KITTTITAS COUNTY COMMUNITY DEVELOPMENT SERVICES

March 19, 2018

Subject: Shoreline Exemption Permit
Melvin Sampson Coho Hatchery (SX-18-00007)

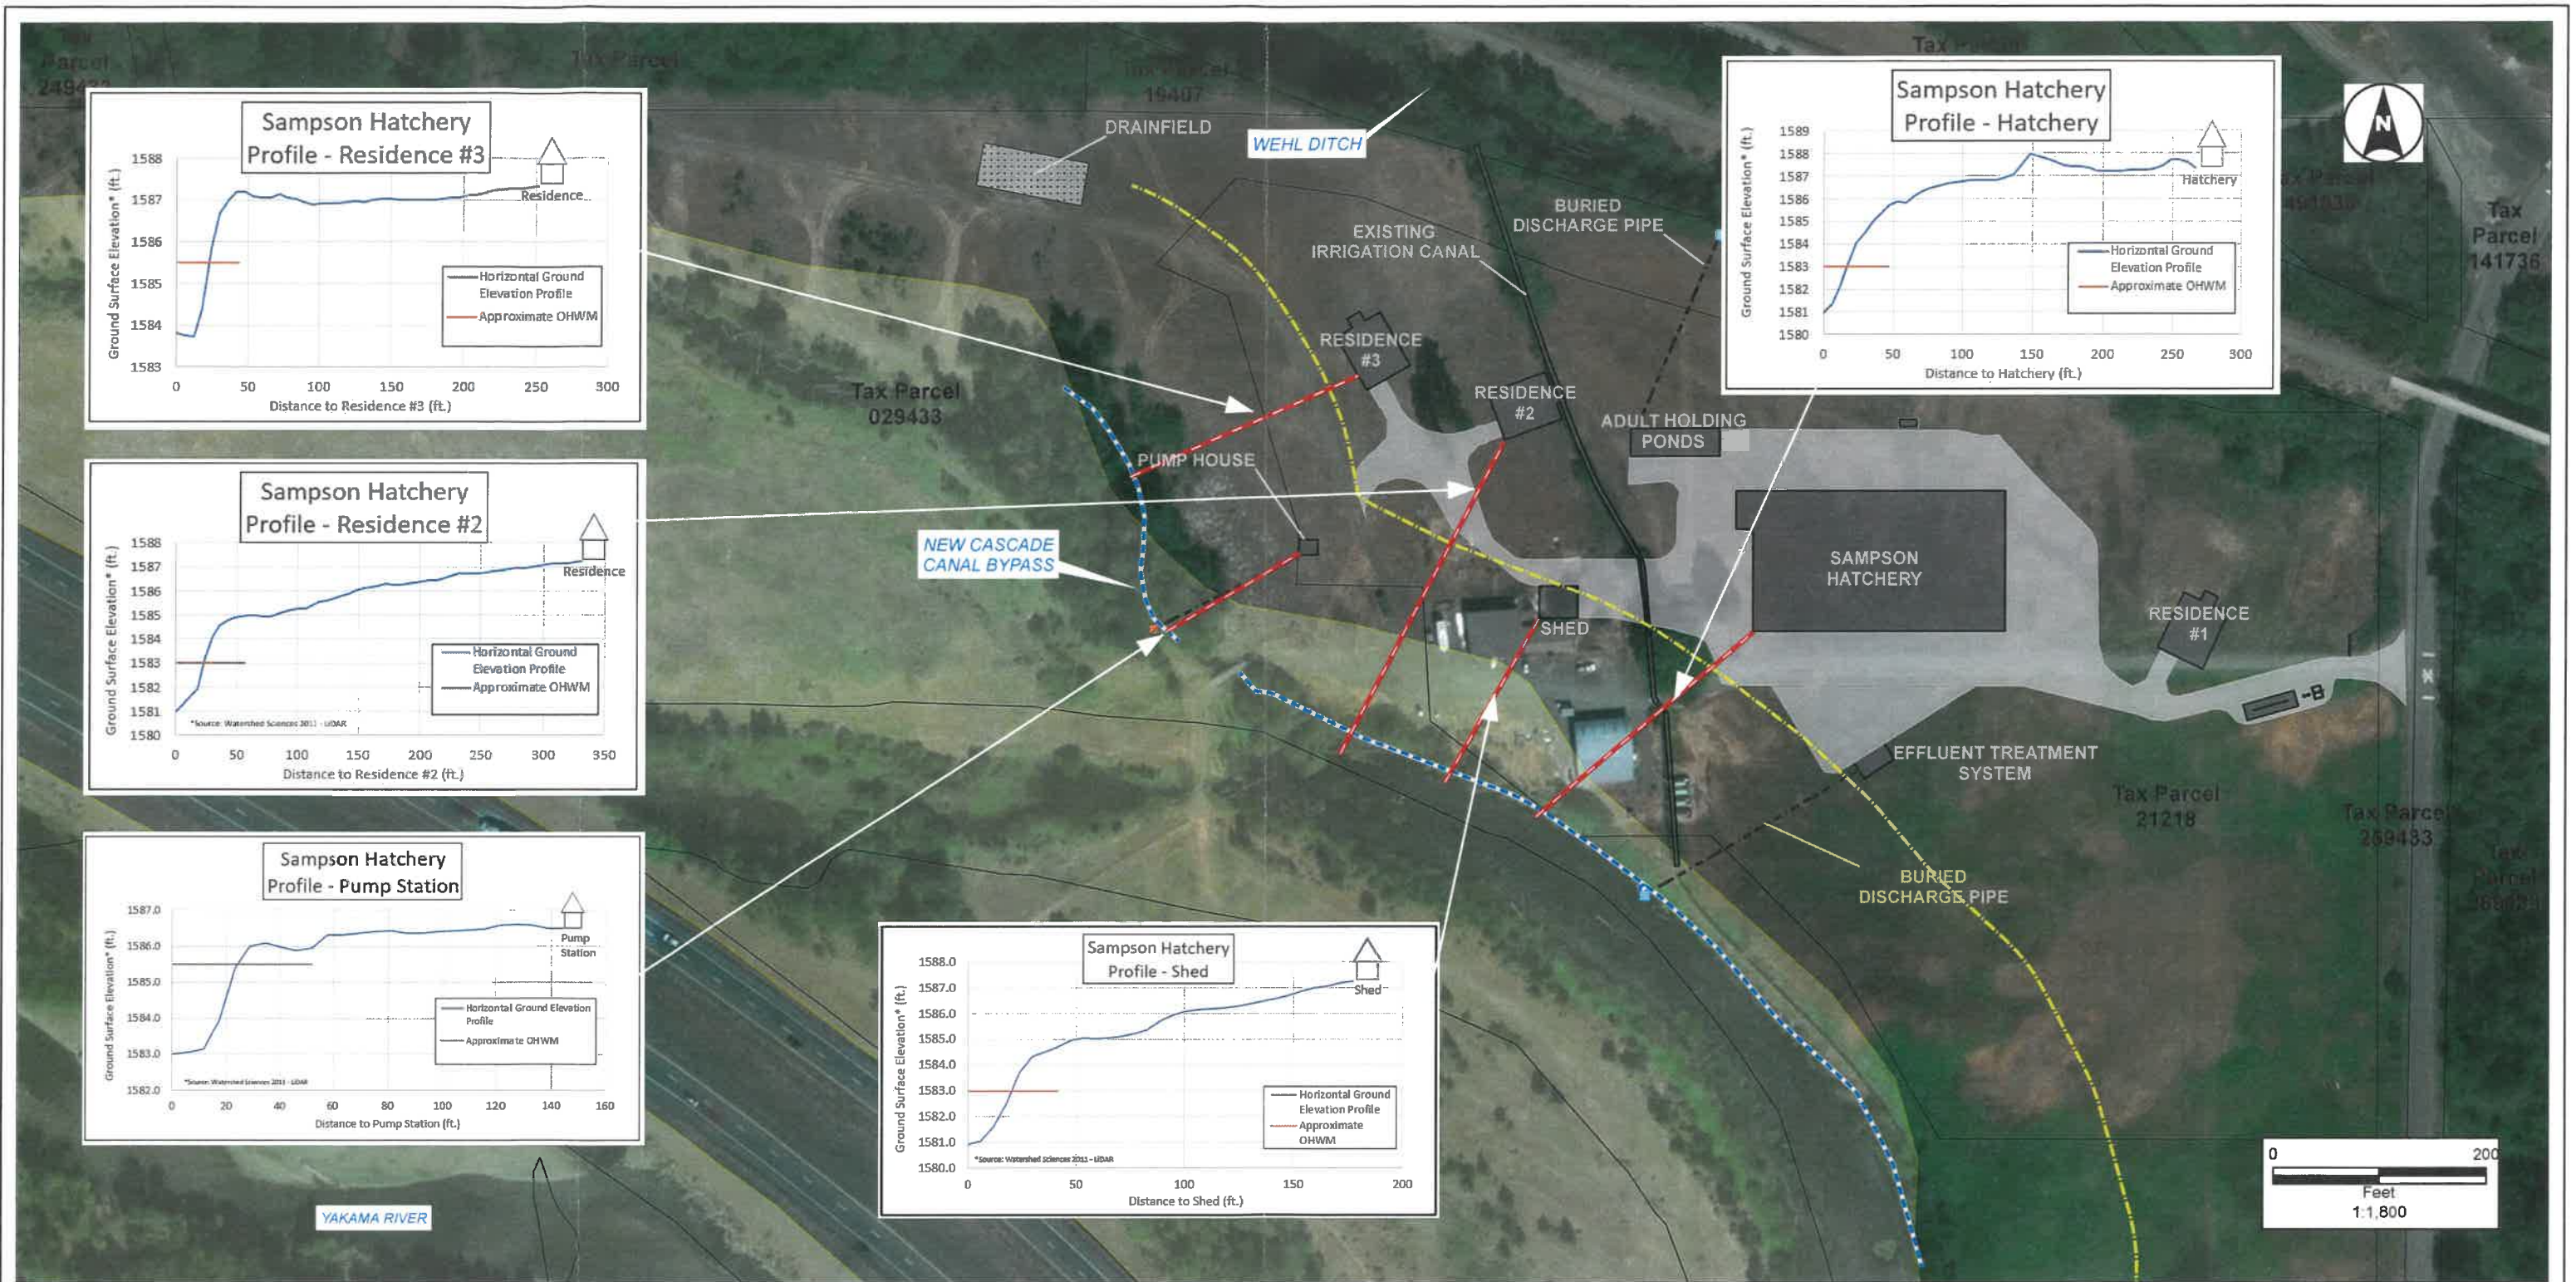
Please provide an updated narrative and site plan which supports that this project meets WAC 173.27.040(2)(p). This is also consistent with exemption requirements in the Kittitas County Shoreline Master Program. The information necessary to meet this exemption includes but is not limited to a completed hydraulic project approval, and documentation showing that Department of fish and wildlife supports and has approved the project.
